Item No. **Report of the Head of Planning, Building Control, Sport & Green Spaces**

Address 31 DERBY ROAD UXBRIDGE MIDDLESEX

Development: Conversion of existing 5-bed dwelling to create 1 x 1-bed flat and 1 x 3 bed maisonette with associated parking and amenity space.

LBH Ref Nos: **56755/APP/2015/3842**

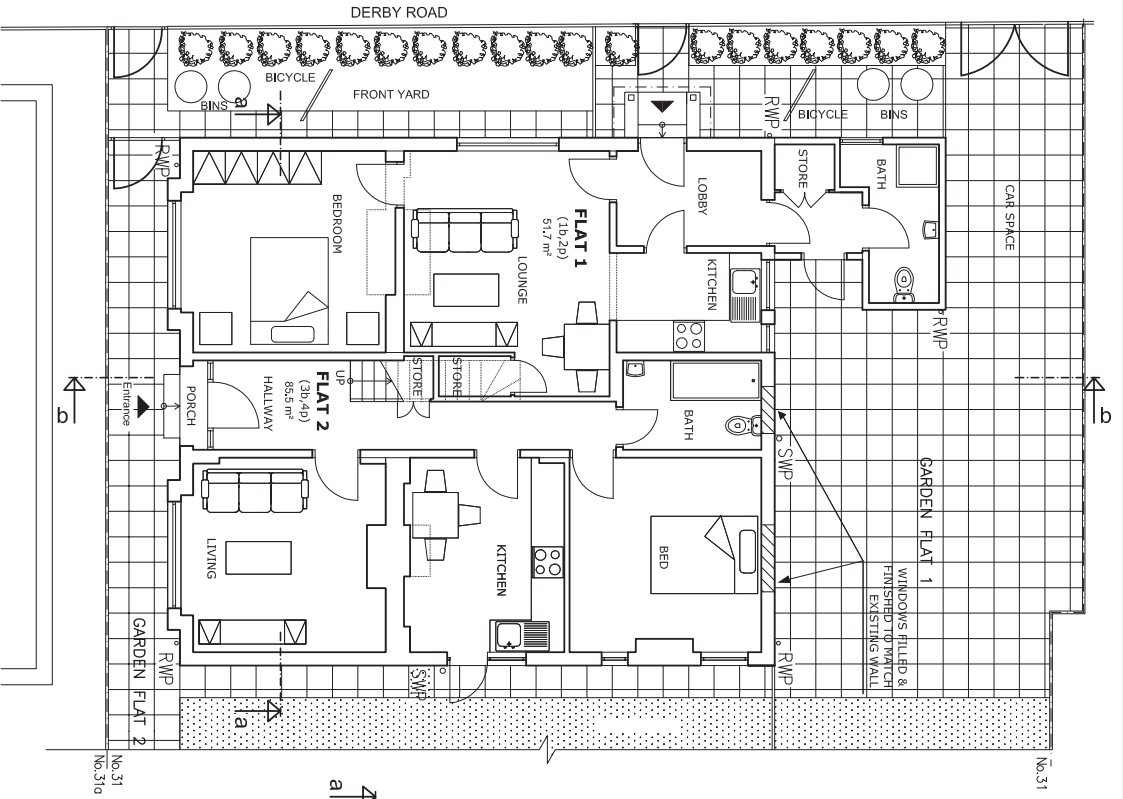
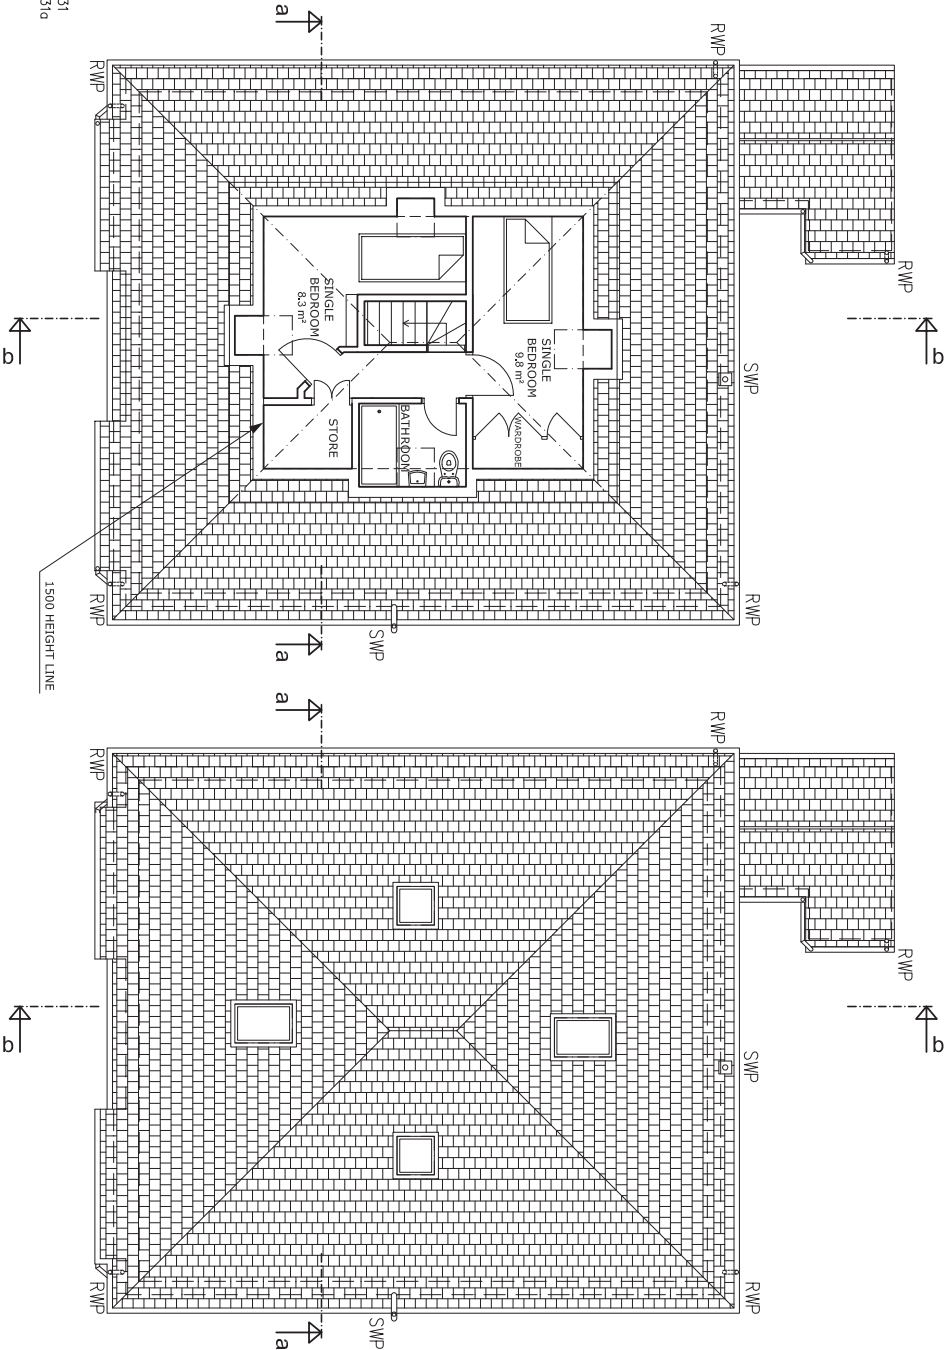
The London Plan Transition Statement sets out the minimum internal floor spaces required for developments in order to ensure that there is an adequate level of amenity for existing and future occupants. The statement requires a 1 bedroom (2 person) flat to have a minimum internal floor area of 50m² and a three bedroom (4 person) two storey dwelling to have a minimum internal floor area of 84 square metres. There is also a requirement for the one bedroom flat to achieve 1m² of built in storage and for the three bedroom flat, 2.5m². Both flats comply with this London Plan standard. In addition the London Plan Transition Statement requires 75% of the accommodation to achieve a ceiling height of 2.5m. 100% of the ground floor accommodation has a ceiling height of 2.85m. The accommodation within the loft achieves a ceiling height of 2.4m and represents 21% of the floor area of flat 2 and therefore complies with this standard. The rooflights to the two first floor bedrooms would achieve an acceptable outlook. As such is considered acceptable in respect of Policy 3.5 of the London Plan and the London Plan Housing Transition Statement (2015).

In this respect, the proposal provides for separate private amenity space for the occupiers of all of the flats to the rear and side of the existing building which is far in excess of the minimum requirement in this regard. The submitted plans also show a strip of communal space for secure bicycle storage and refuse storage behind the fence which could be conditioned accordingly.

The flats would be required to be provided with a well screened storage area for refuse awaiting collection. Provision for this has been made within the site layout within 25 metres of the highway and subject to condition, a suitable form of enclosure can be provided in a position that does not impinge on the outlook from the ground floor window of Flat 1.

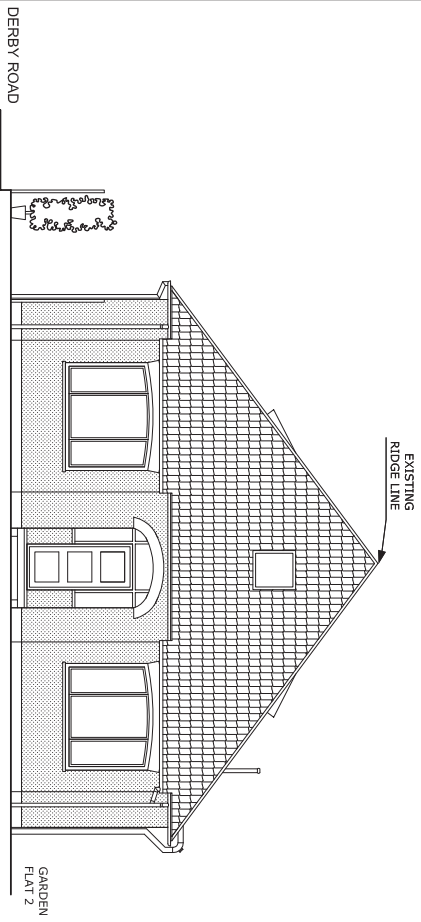
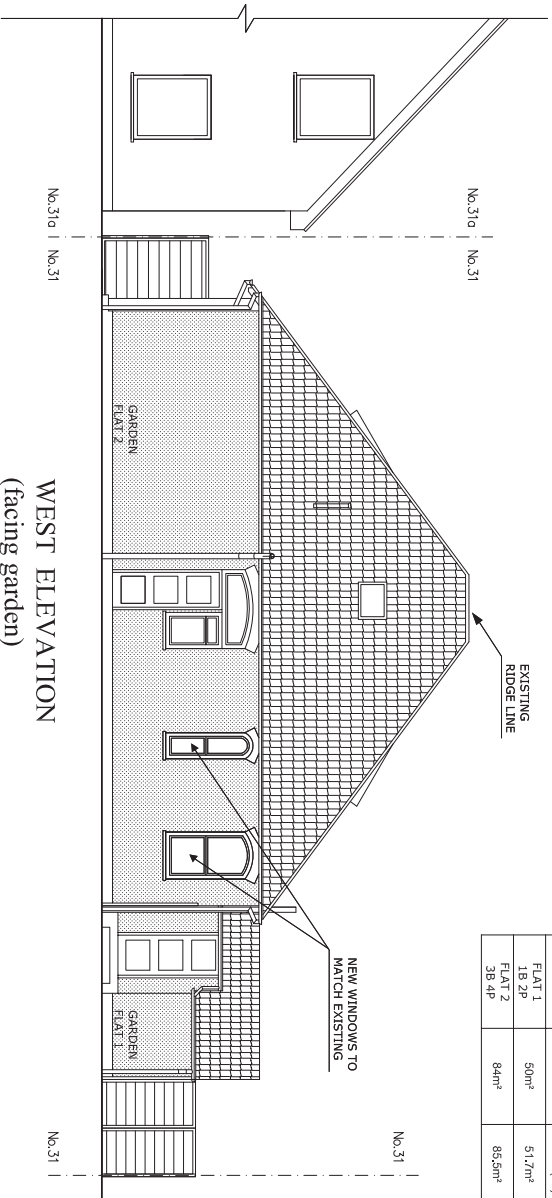
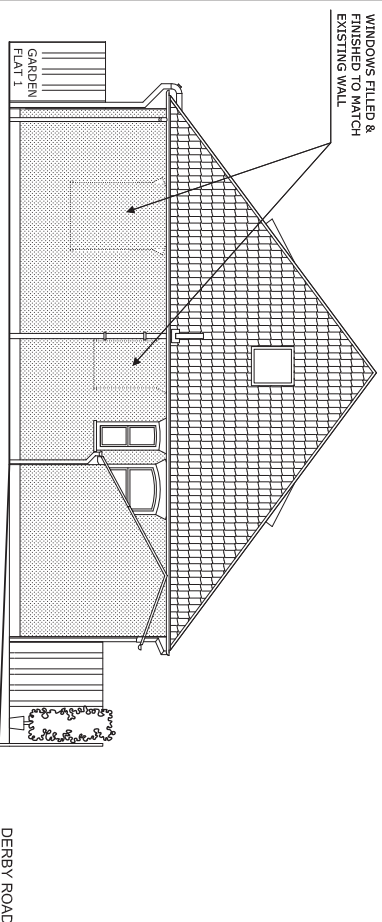
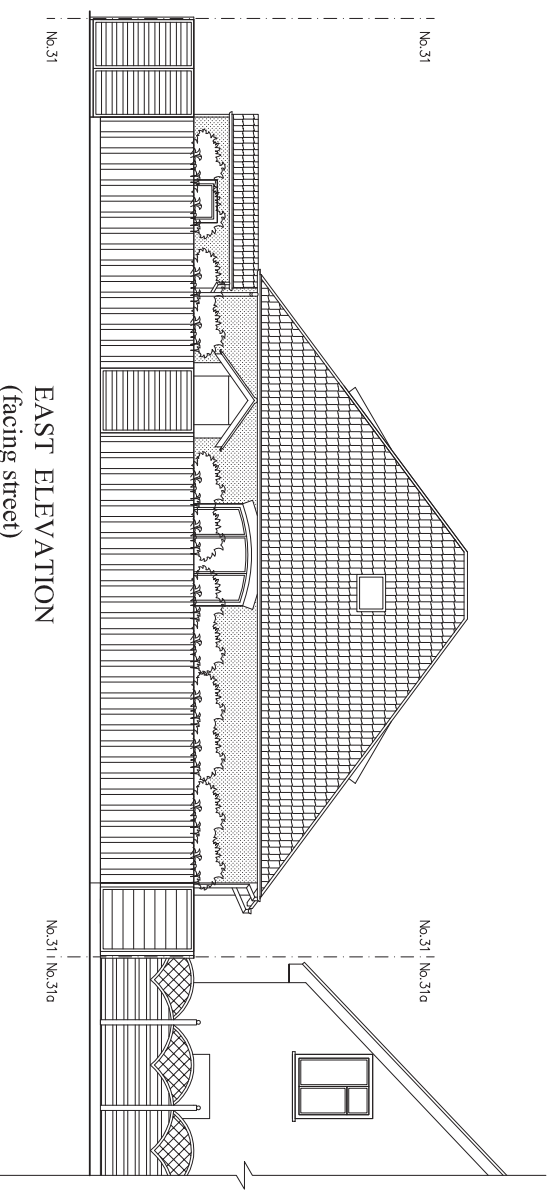
The revised scheme involves the infilling of two windows in the south elevation and the insertion of two windows in the west facing elevation facing the garden.

The proposals include minimal alterations to the elevations that would be visible from the street above the existing boundary fence in Derby Road and would not detract from the character and appearance of the host building or the locality in accordance with Policy BE1 of the Hillingdon Local Plan: Part One - Strategic Policies (November 2012) and Policies BE13, BE15 and BE19 of the Hillingdon Local Plan: Part Two - Saved Unitary Development Plan Policies (November 2012).

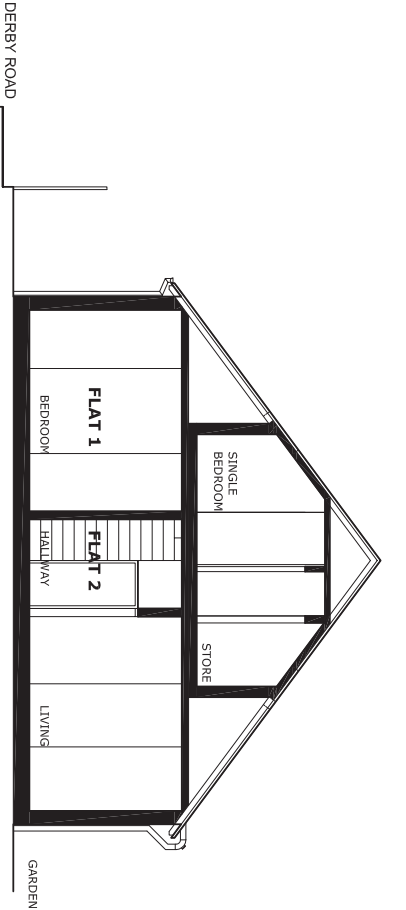
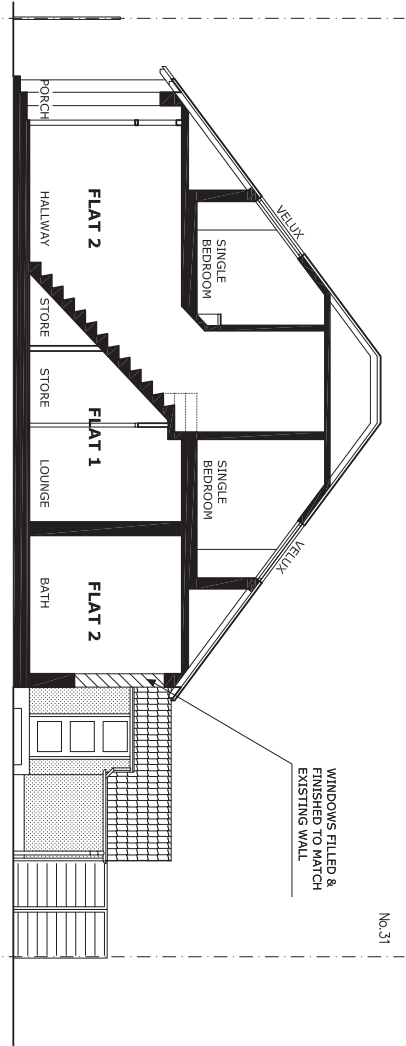
The application seeks planning permission for the conversion of existing 5-bed dwelling to create 1 x 1-bed flat and 1 x 3 bed flat with associated parking and amenity space. The original submission was for three flats. However concerns were raised in respect of the headroom to the first floor flat not complying with the London Plan Housing Standards Transition Statement and the scheme has been amended to two dwellings to address the concerns.

Officer note: Revised plans were submitted to address the highway officer comments. The scheme has since been amended to reduce the number of proposed dwellings to two with the crossover and parking remaining as existing.
